Item No.	Report of the Head of Development Management and Building Control
----------	---

Address: 95 PINNER ROAD NORTHWOOD

Development: Retention of single storey rear extension (Retrospective application)

LBH Ref Nos: 27283/APP/2023/1732

Drawing Title EXISTING, C/F

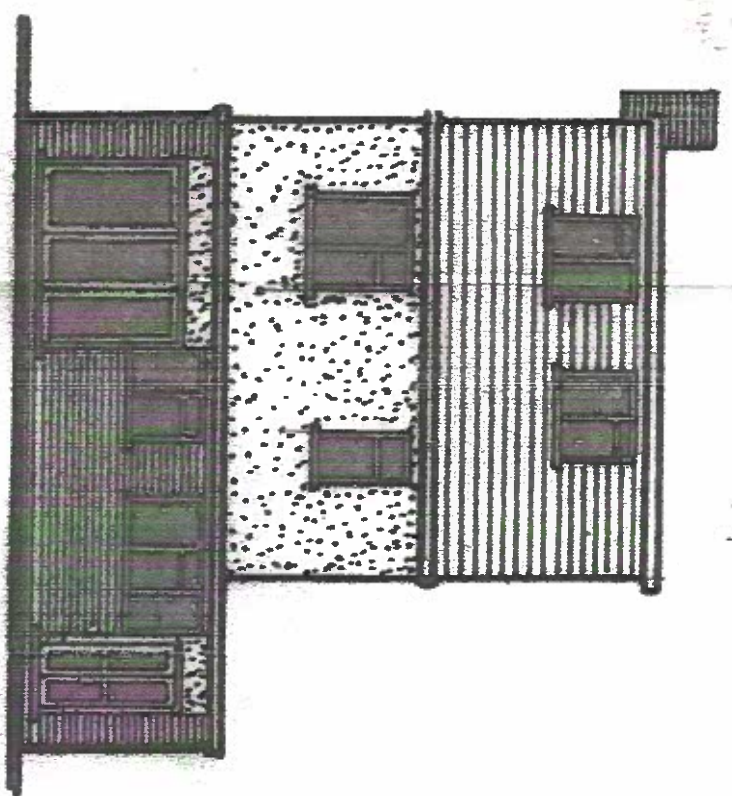
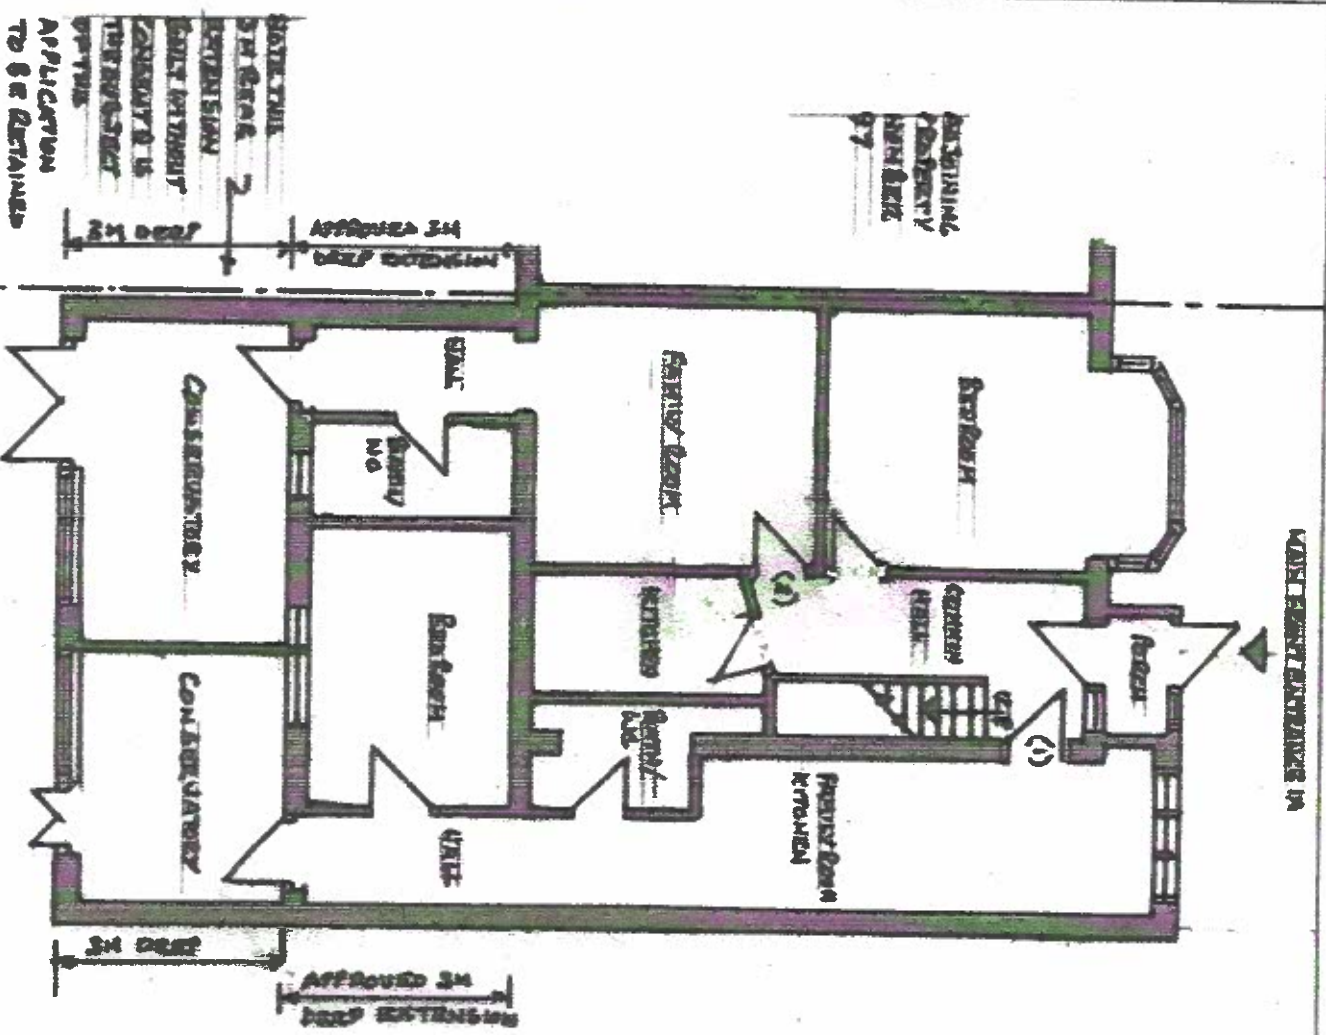
The application seeks the retention of a 3metre deep single storey rear extension to the building, forming additional accommodation for the 2no proposed ground floor units (which are subject of a separate certificate of lawfulness application for an existing use under ref: 27283/APP/2023/1723.

Whilst marked on the floor plans as 'conservatory' it was evident that the rooms were and could be used as habitable accommodation including as an additional bedroom, which was at the time of a case officer's visit, was how the rear room of the 'ground floor unit 2' was set out.

The proposed single storey rear extension measures 2.8metres in height and is set under a flat roof. Being attached to an existing 3metre deep single storey rear extension, the development would cumulatively result in a 6metre deep extension which far exceeds the 3.6m limit set out in Policy DMHD 1. However, it is noted that there are similar developments nearby including at Nos. 85 and 89. In view of the surrounding site context, the development would not introduce an alien feature and is therefore on balance, not considered to be harmful to the character and appearance of the area.

The overall size of both units would be below the floorspace standards. Unit 2 proposes an internal living & dining room with no external windows. It is considered that some of the proposed habitable rooms would fail to maintain an adequate natural ventilation, outlook and source of natural light.

A daylight/sunlight assessment to demonstrate compliance with the BRE's "Site Layout Planning for daylight and sunlight, a Guide to good practice" (2022) has not been submitted with the application. Given the juxtaposition of the rear bedroom window which would be formed of an internal wall 3metres behind the rear wall of the proposed rear extension, it is unlikely that sufficient daylight/sunlight would be provided.

It is also noted that part of the rear bedroom window marked out on the floor plan as serving unit 1 is shown to encroach onto the rear room of unit 2. This would result in loss of privacy between occupants of the HMO.

It is considered that all the proposed habitable rooms, and those altered by the extension, would not maintain an adequate outlook and source of natural light, therefore failing to comply with the Housing quality and standards of the London Plan (2021).
